Recommendation Report for Works to Tree(s) on trees subject to a Tree Preservation Order (TPO)

REF NO: R/263/21/T

LOCATION: Various locations throughout Sea Estate
Rustington

PROPOSAL: Various works to various trees.

SEA ESTATE RUSTINGTON -
PLAN SHOWING PROPOSED TPO WORK 2021/22
REFER TO TABLE A FOR DESCRIPTION OF WORK

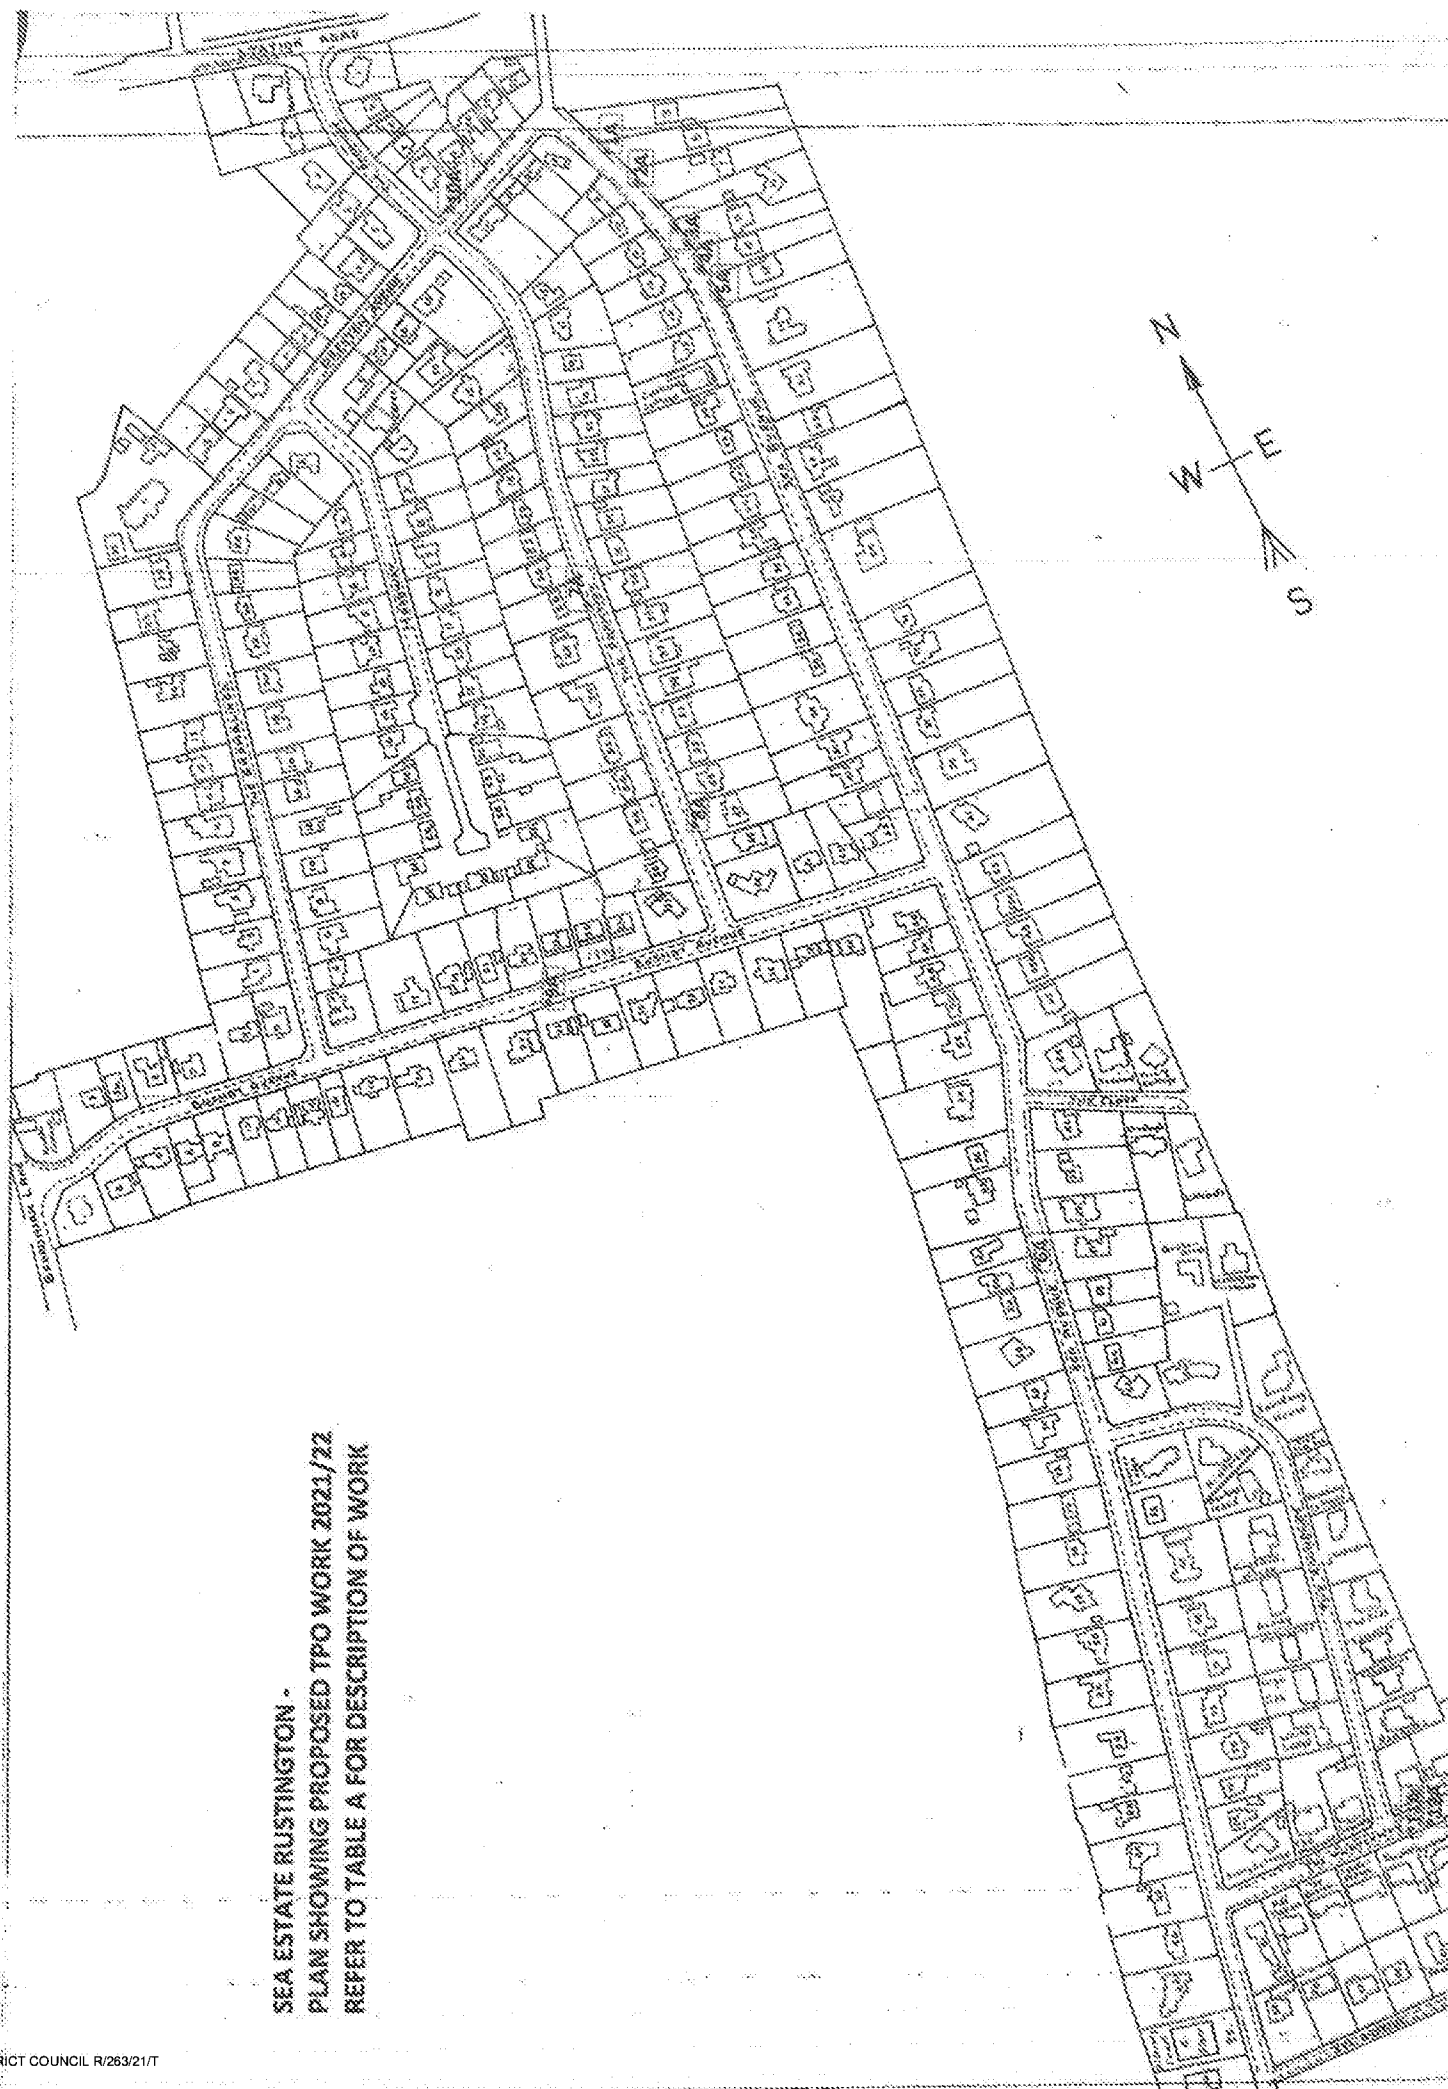
- I am not satisfied that there is justification for whole crown reduction pruning to Nos. 11A and 12A. They are exposed trees with correspondingly compact yet highly attractive crown profiles. They are of late-mature age class and outwardly appear to be free from significant structural defect and in fine physiological condition. They require careful management that respects their age and vulnerability to environmental changes and disease progression.

- Whilst known for their tolerance of coastal conditions they are prone to small branch breakage during inclement weather and over-extended limbs may also develop longitudinal splits. The latter is often a progressive event and usually identified during routine inspection long before they become unduly

hazardous. They are also known for being wind firm at the root-plate and free from pests and disease, the notable exception being a slow but progressive fungal infection which causes scattered dieback of distal branches. Surprisingly for trees of this age, they appear largely free of such disease and so are especially fine examples of their type.

- Crown reduction may reduce the frequency of small branch breakage in the short term but suddenly exposing the crown interior in such an exposed location may set in train a loss of vitality and structural integrity which could not be recovered.

- Following the removal of tree Nos. 11A and 12A from the proposal, the Tree Officer recommends APPROVAL subject to the following conditions and informatives.

Following the Tree Officer's comments, correspondence with the applicant was undertaken and proposed works to tree Nos. 11A and 12A were removed from the application.
